A303 Amesbury to Berwick Down

**8.3(1) - Statement of Common Ground – Historic Buildings
and Monuments Commission for England**

August 2019

STATEMENT OF COMMON GROUND – Historic Buildings and Monuments Commission for England

Drawing Title
STRUCTURES DRAWINGS
WESTERN TUNNEL PORTAL
REGULATION 5(2)(o)
SHEET 8 OF 13

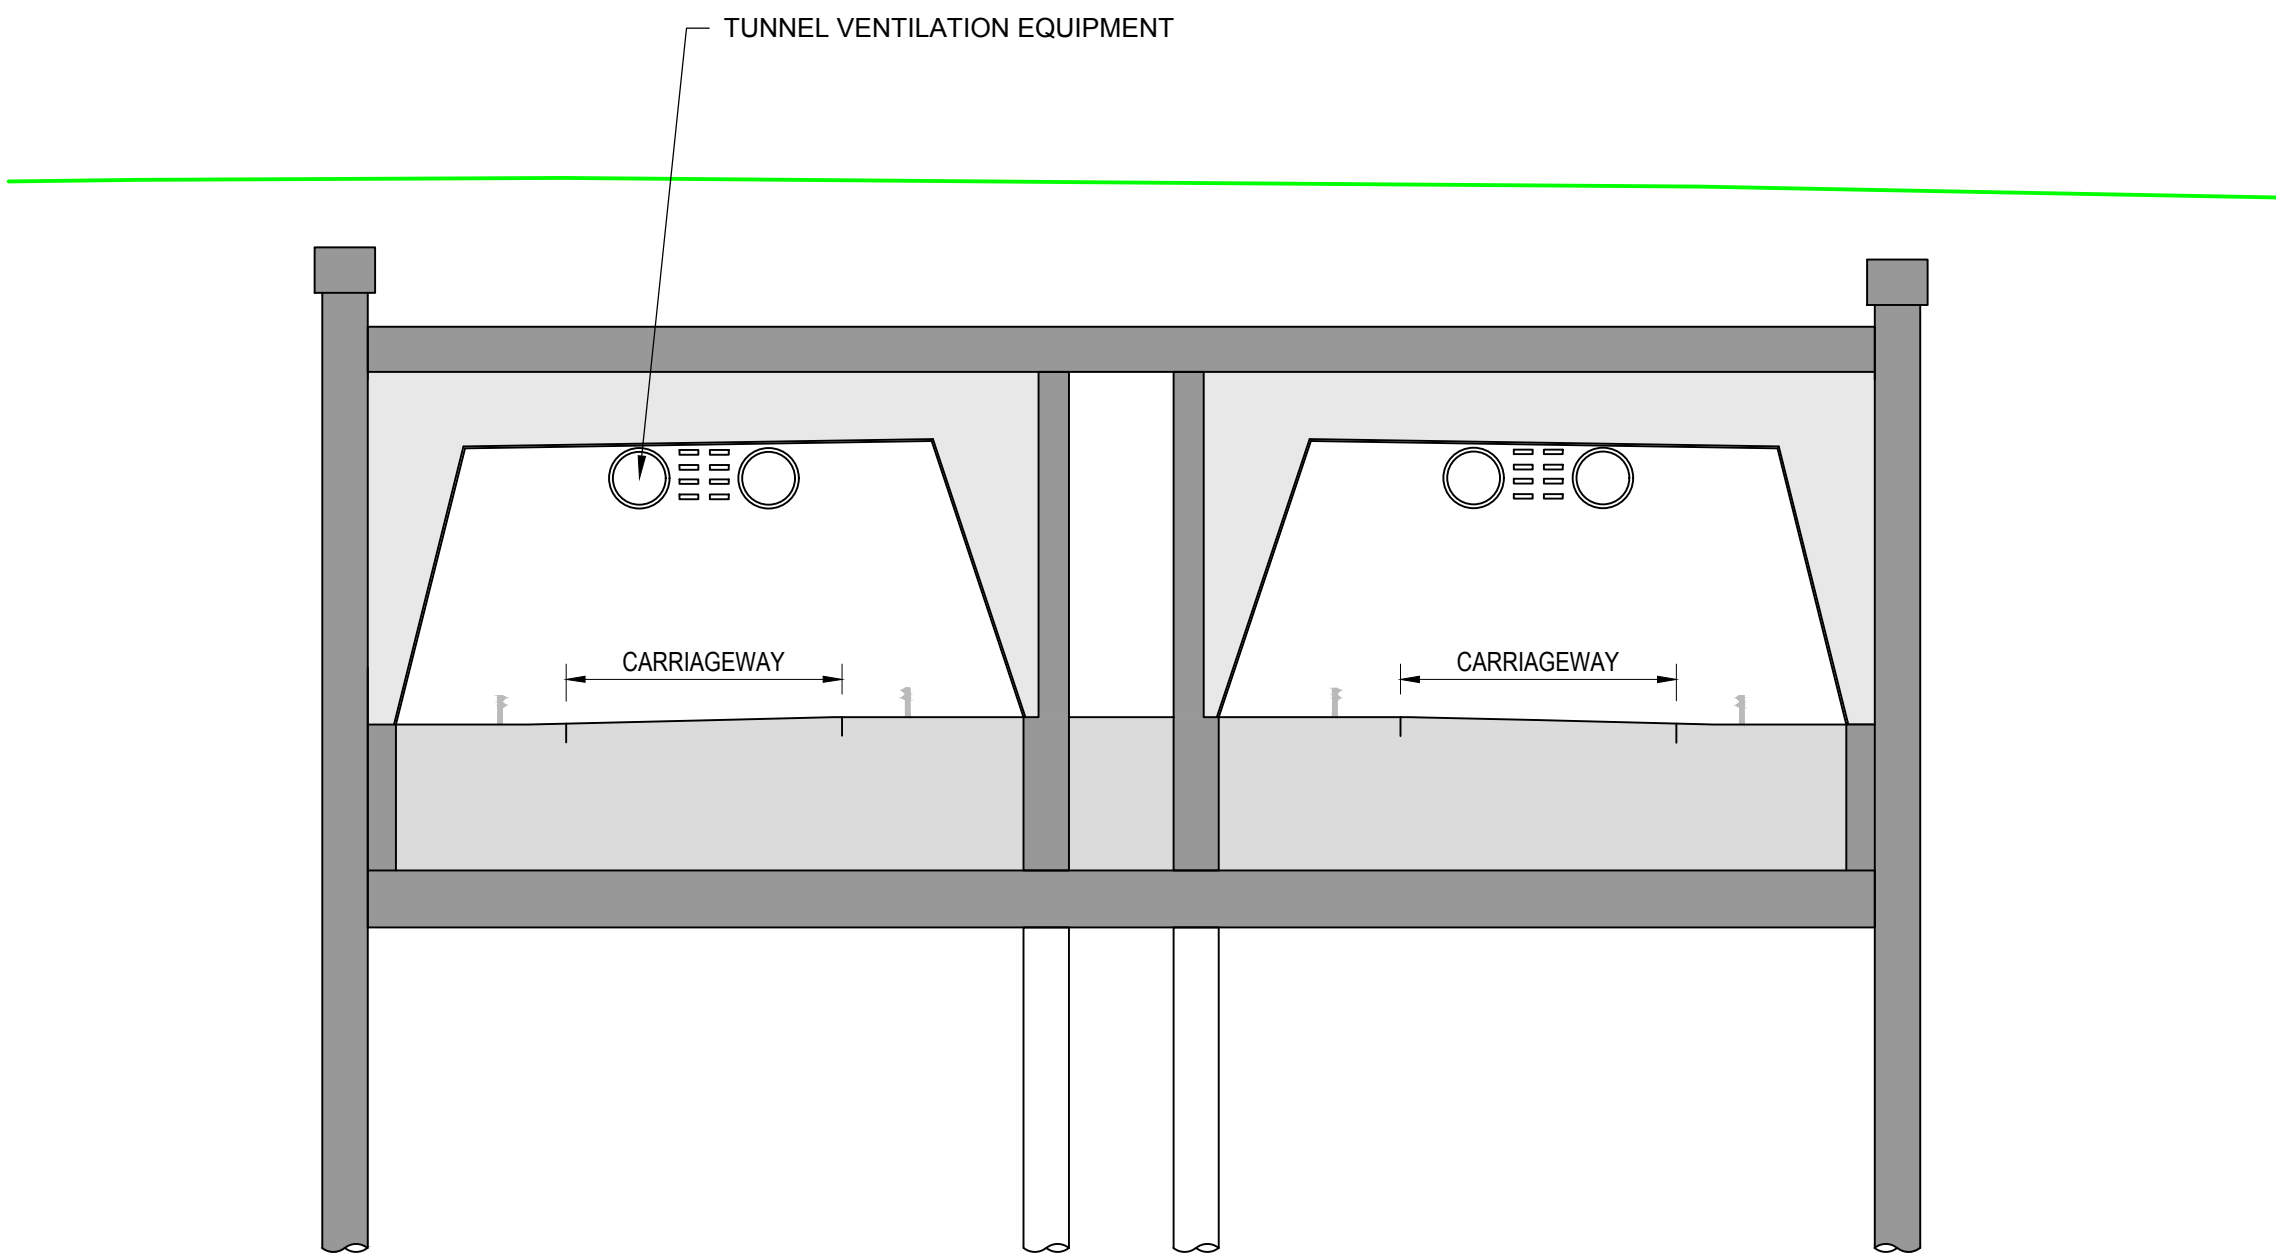
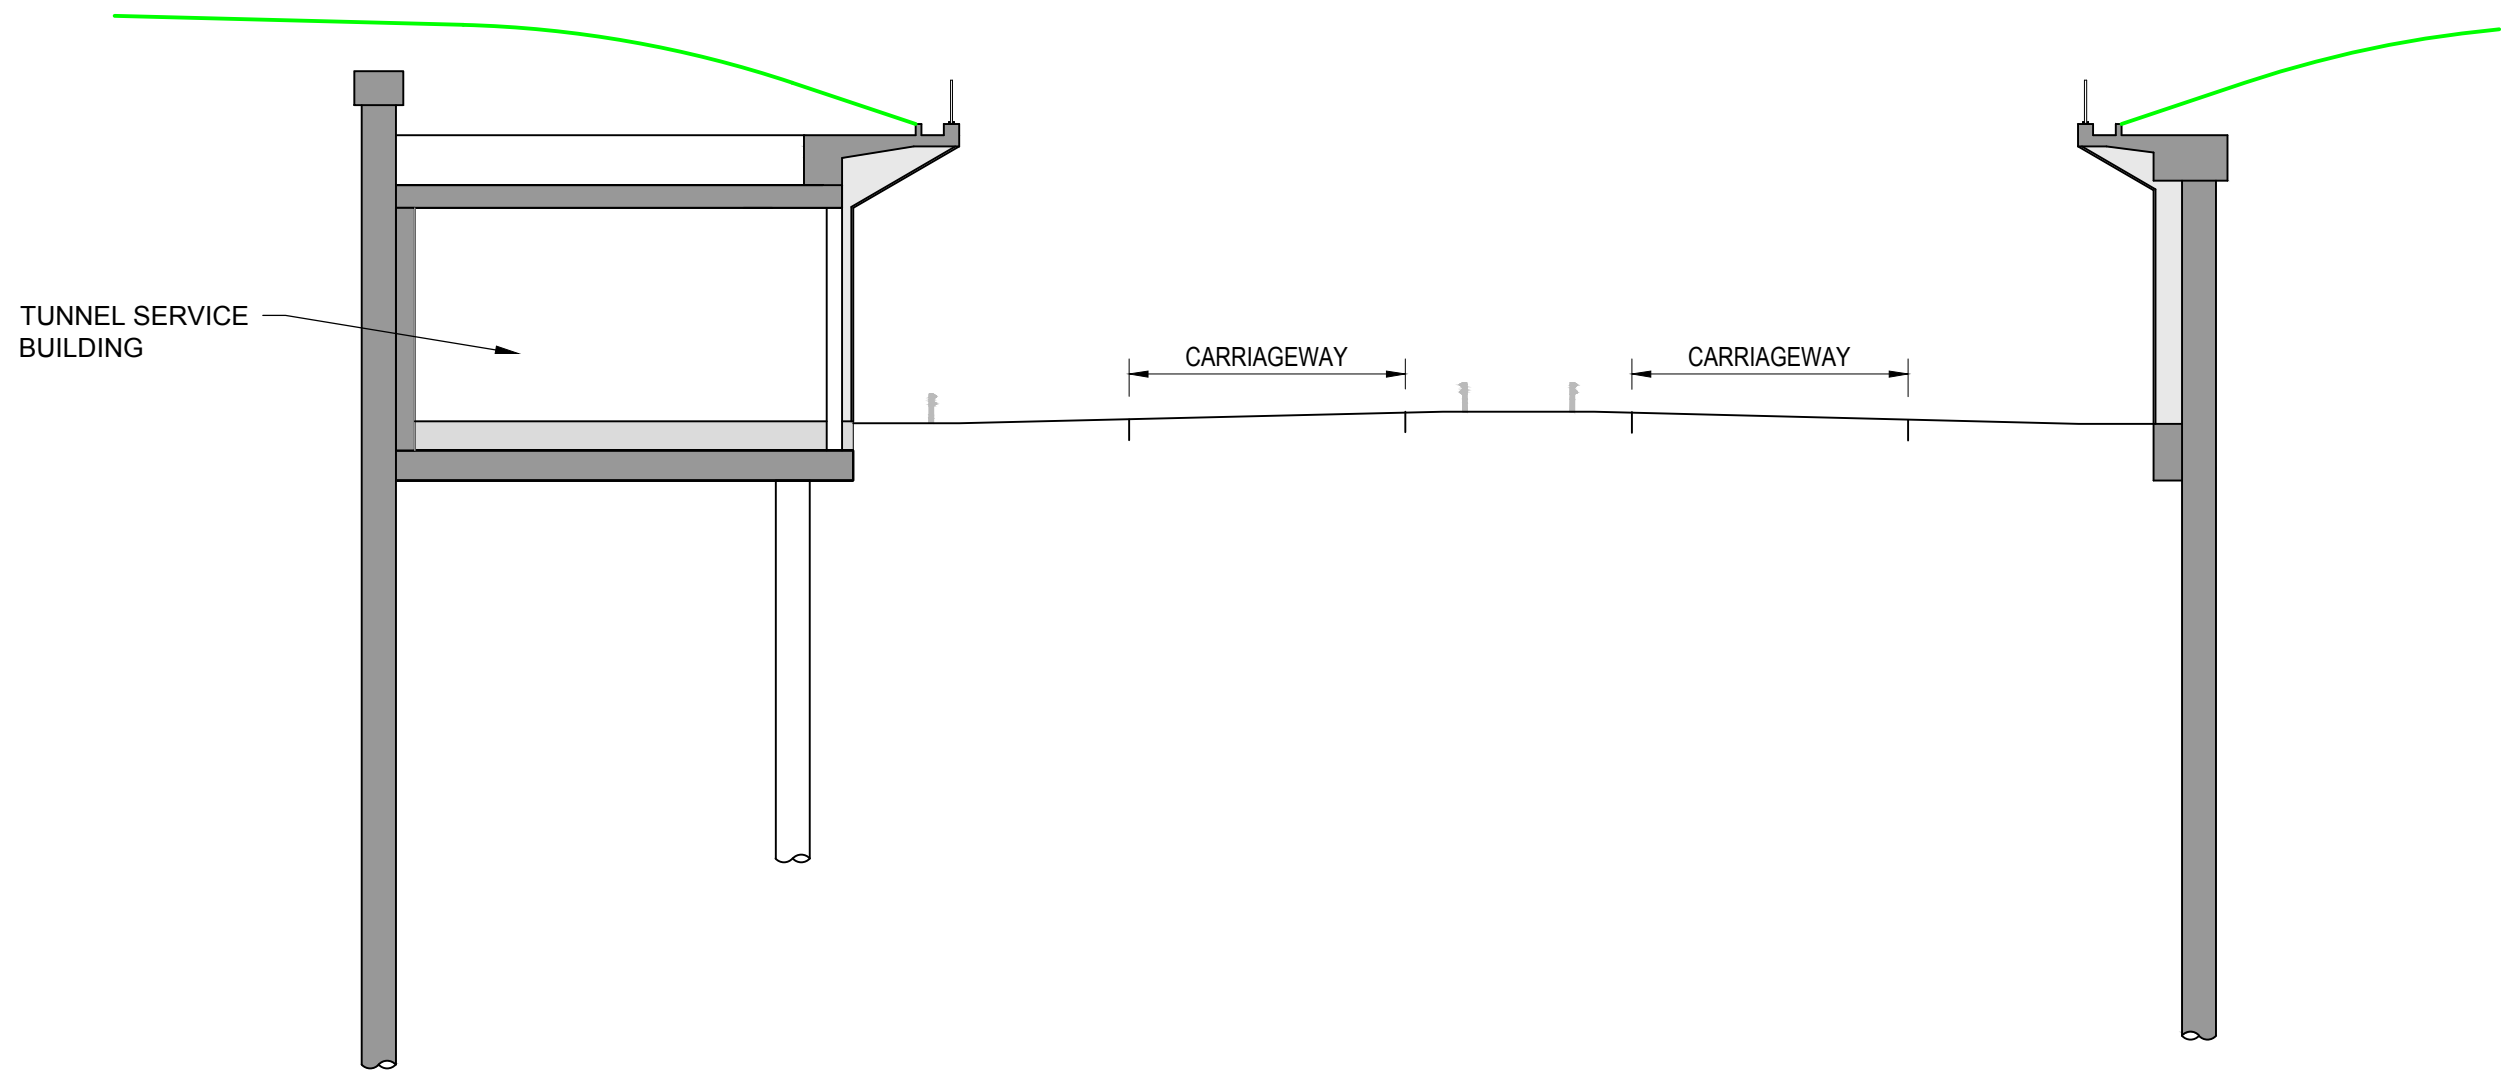
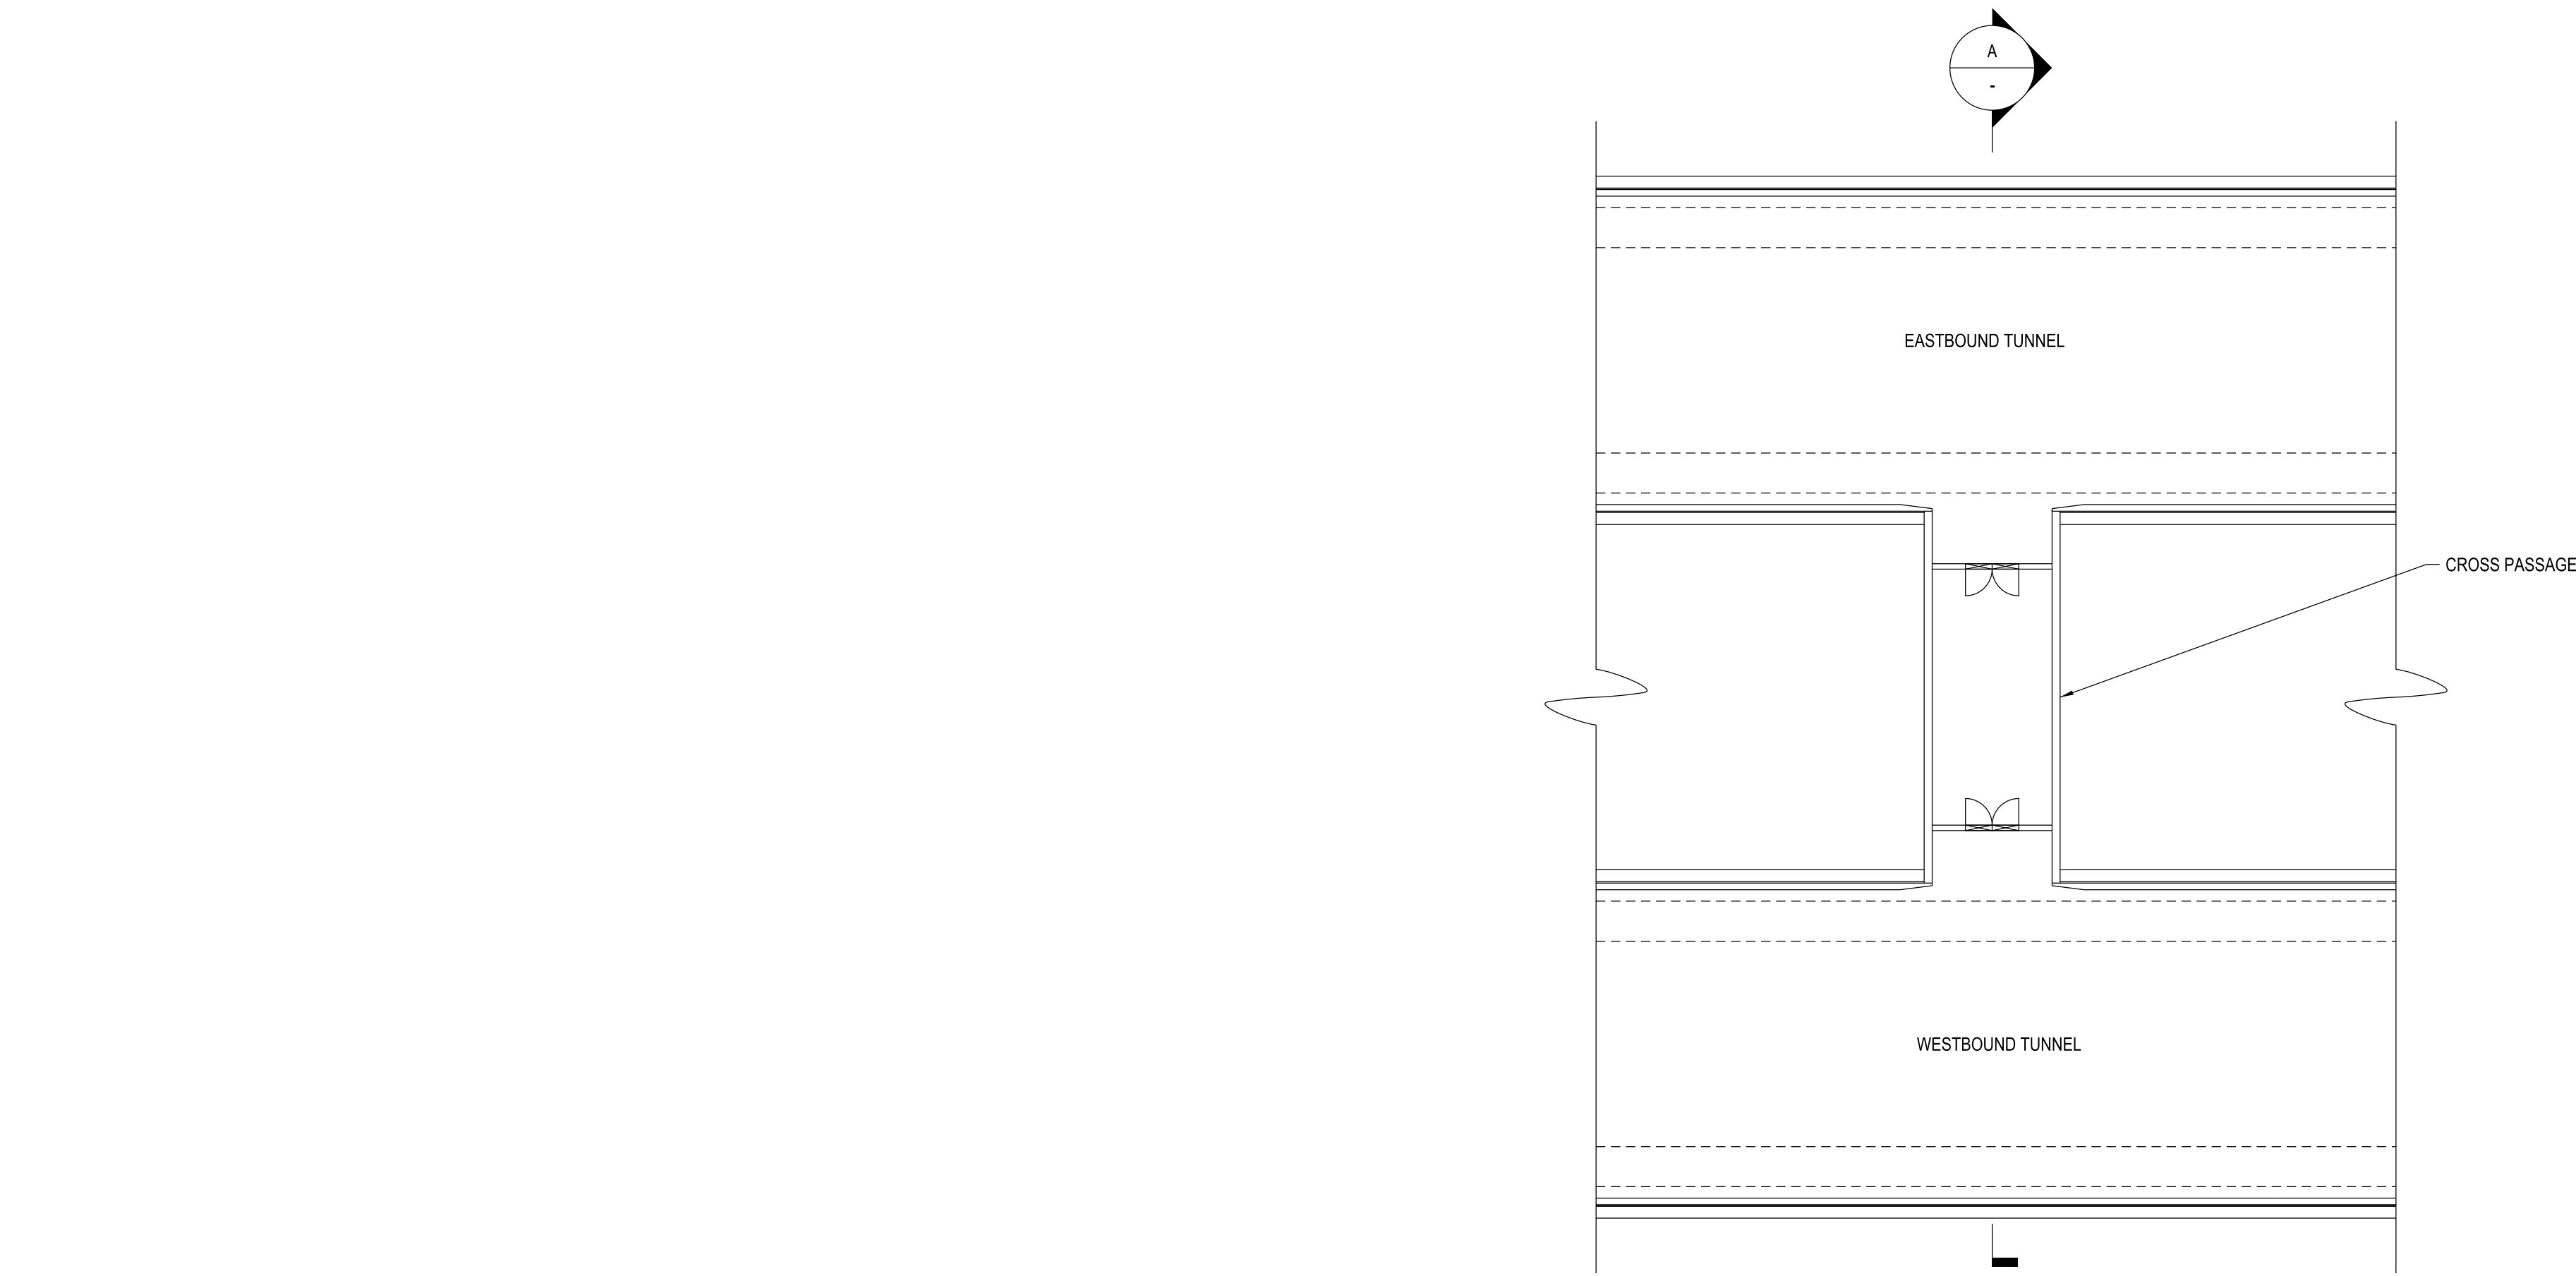
<p>[REP6-053]</p>	<p>ExA question DCO.2.51 – Requirement 4, OEMP</p>	<p>Page 10</p>	<p>Detail is needed in relation to the tunnel canopies, including design detail, confirmation of their positioning, and landscape proposals to understand how they will be integrated into the landscape.</p> <p>A greater degree of precision is needed in relation to the actual positioning of the tunnel portals given the sensitivity of the landscape. Historic England considers the limits of lateral deviation westwards in the first draft DCO of 200m for the western portal to be unjustified at this point.</p> <p>Detail is needed in relation to the management of light levels (both from infrastructure and vehicle headlights), because of effects of light on the night time historic environment, in particular, in relation to the tunnels and retained cuttings within the SAAS WHS.</p> <p>In our Written Representations [REP2-100] (paragraph 7.6.24) HBMCE indicated that whilst it is possible that some aspects of lighting for the Scheme might be comfortably addressed at Detailed Design Stage, sufficient indication of the parameters for decision making must be subject to Examination. We advised that this might be addressed through production of a lighting strategy for the Scheme. In</p>	<p>stage immediately before implementation.</p> <p>The OEMP [REP6-011] includes a design vision together with a set of design principles for key elements of the Scheme. Highways England will consult key stakeholders, including HBMCE, on the external appearance of the following elements of the Scheme within the World Heritage Site:</p> <ul style="list-style-type: none"> a) The tunnel service buildings (Work No.1D(ii)); b) Portals structures (Work Nos. 1E(ii) and 1G(iii)), retaining walls (part of Work Nos. 1D(ii) and 1H(ii)) and Green Bridge Four (Work No.1d(i)); and c) Public rights of way, including pedestrian, cycling and non-motorised user provision and wayfinding including surfacing, materials, fencing and gating. <p>Outside of the World Heritage Site Highways England will consult key stakeholders, including HBMCE, on the external appearance of the following:</p> <ul style="list-style-type: none"> a) Signing and lighting at the new Longbarrow junction (Work No.1C(ii)); and b) Signing and lighting at the Countess junction (Work No.1H(iv)).

<p>Current position</p>			<p>relation to the tunnel portals specifically (7.6.50) we advised that clarification regarding how light levels will be managed at these points in the landscape to avoid any harm to Attribute 4 of the OUV of the WHS. Subsequently HBMCE have continued through heritage design meetings in relation to the OEMP to discuss the provision for lighting design at the tunnel portals and elsewhere where there is potential for the WHS to be affected.</p> <p>As noted above, the OEMP remains the focus of discussion on the detail of the Scheme. We would expect the detailing of key engineering elements to be covered as part of this discussion.</p>	<p>Longbarrow Junction</p> <p>The layout of the proposed Longbarrow junction is shown on sheet 5 of the Works Plans [APP-008], described in Schedule 1 and shown indicatively on Sheet 5 of the General Arrangement Drawings [APP-012]. The junction has been located as close as possible to the point of intersection of the A303 and A360 alignments while at the same time minimising impact on the WHS and other environmental receptors.</p> <p>Tunnel Approaches and Portals</p> <p>Visualisations of the tunnel approaches and portals can be found in section 6.4 of the Design and Access Statement [APP-295]. Further detail is shown illustratively on sheets 7, 8, 10 and 11 of the Structures Drawings [APP-017]. Additional visualisations were submitted at Deadline 6, which are currently being reviewed by HBMCE. Further visualisations, in response to ongoing dialogue, are being submitted at Deadline 7.</p> <p>Levels in relation to existing Topography</p> <p>Proposed road levels in relation to existing ground levels are shown in the Engineering Drawings (Plans and Profile) [APP-010]. These drawings</p>

<p>within and beyond the WHS, considering such matters as; landscaping, structures, surfacing, lighting and public rights of way.</p> <p>A description of the earthwork landscape proposals is included in paragraph 2.3.55 of Chapter 2 of the ES [APP-040] For further detail refer to ES chapter 7 2 Landscape and Visual Effects [APP-045]. The final landscaping for the Scheme is controlled by requirement 8, which requires a landscaping scheme to be approved by the Secretary of State for each part of the Scheme before it is commenced.</p> <p>Lighting</p> <p>The majority of the Scheme would not be lit. There will be no external road lighting within the WHS outside the tunnel or Green Bridge 4 and this lighting will be designed to avoid light spill. There will be no lighting to retaining cutting walls or the external walls of tunnel control buildings during the routine operation of the Scheme. The existing lighting provision at Countess roundabout will be replaced with a modern system that will reduce light spill. The lighting under Green Bridge No. 4 will only operate during the day time and will be dimmer controlled at dusk and dawn to avoid</p>

<p>sudden bursts of light emitting into the landscape at these specific times of the day. There will be no lighting on any PRow within the Scheme. This lighting is provided for in the OEMP [REP6-011], and paragraph 4 of Schedule 2 of the draft development consent order [REP6-005] requires the Scheme to be carried out in accordance with the OEMP.</p> <p>Green Bridge No 4</p> <p>Highways England has committed, via the OEMP [REP6-011] to the width of Green Bridge No. 4 being 145 – 149.9 metres. It also contains the design vision, additional design commitments, design principles to help guide the development of the detailed design together with a robust stakeholder consultation mechanism to involve heritage stakeholders, including HBMCE, in the development of aspects of the detailed design. Compliance with the OEMP is secured via requirement paragraph 4 of Schedule 2 of the draft development consent order [REP6-005].</p> <p>Tunnel Canopies</p> <p>Highways England has prepared an update to the OEMP [REP6-011] which contains additional design commitments (including in relation to</p>
